From: Mark Jones
Sent: 18 July 2017 21:17
To: Planning
Subject: FW: M 56 17 HH 8 Beaconsfield Close Middleton

M 56 17 HH 8 Beaconsfield Close Middleton

Further to our email we attach our plans and elevations revised to reduce the foot print omitting the rear study bedroom.

Title
Elevations as Proposed

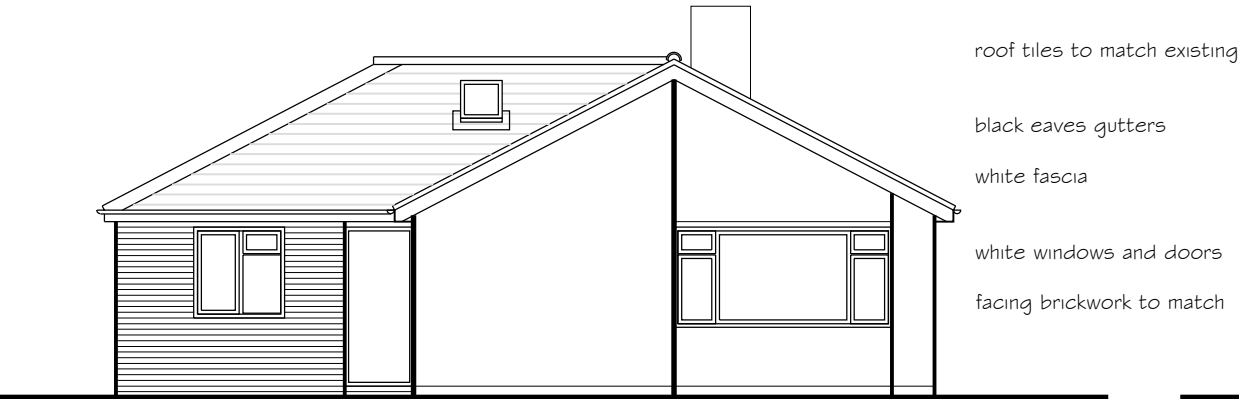
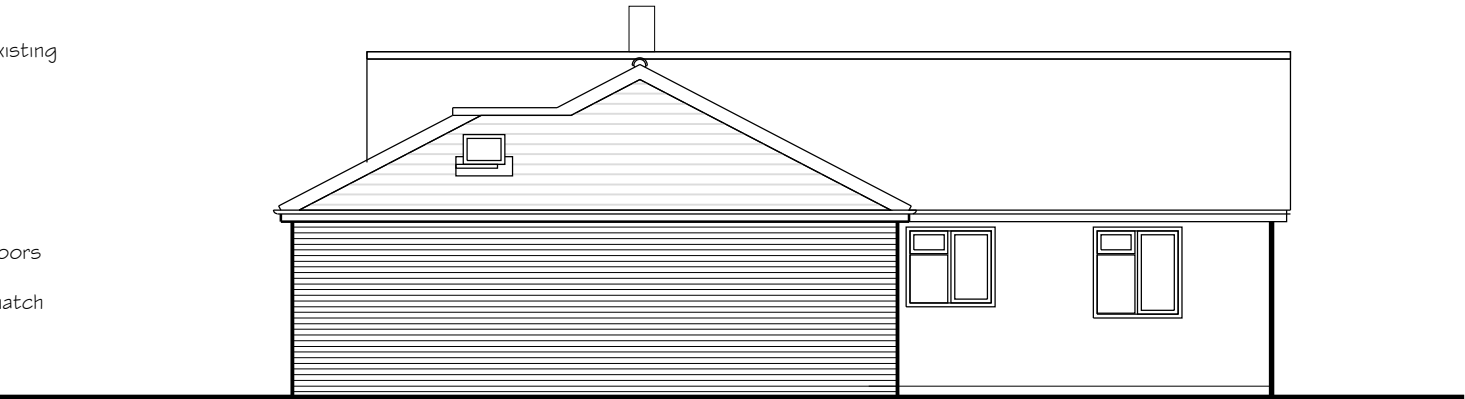
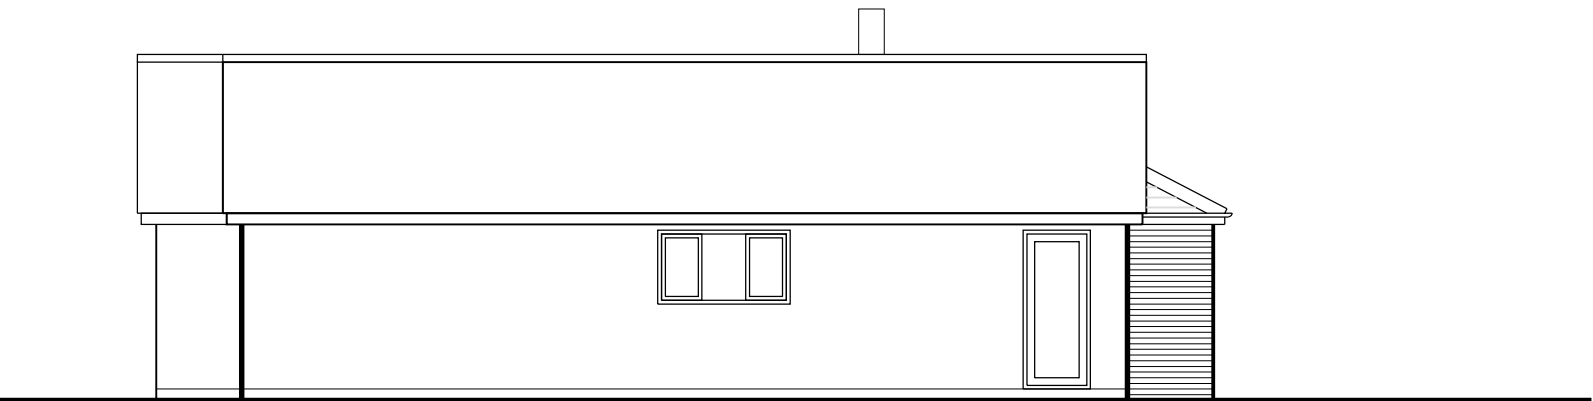
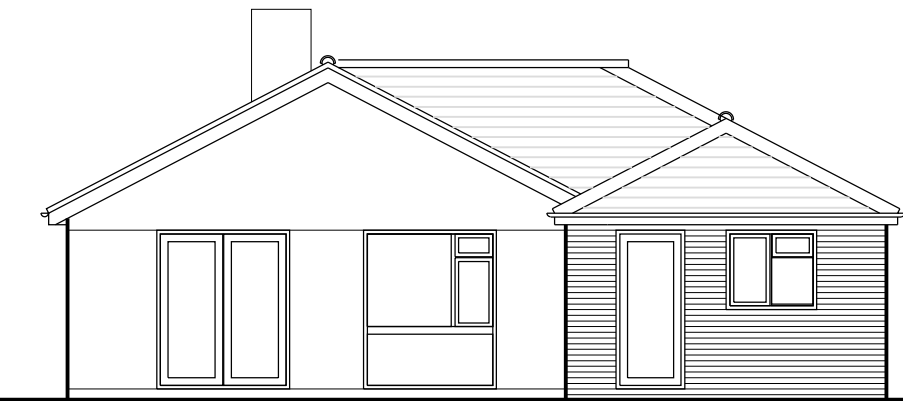
I do have concerns regarding the rear part of the extension coming out 4m along the side boundary and its impact upon the amenity of the adjoining occupiers with regard being unduly dominant and creating an unacceptable sense of enclosure on this adjoining property. At this stage I have no issue with the extension and the change in design and increased roof along the side of the house replacing the garage.

As mentioned this is my opinion and needs to be confirmed by managers. However, one option would be to reduce the rear part of the extension albeit this would probably mean the loss of the bed/snug.
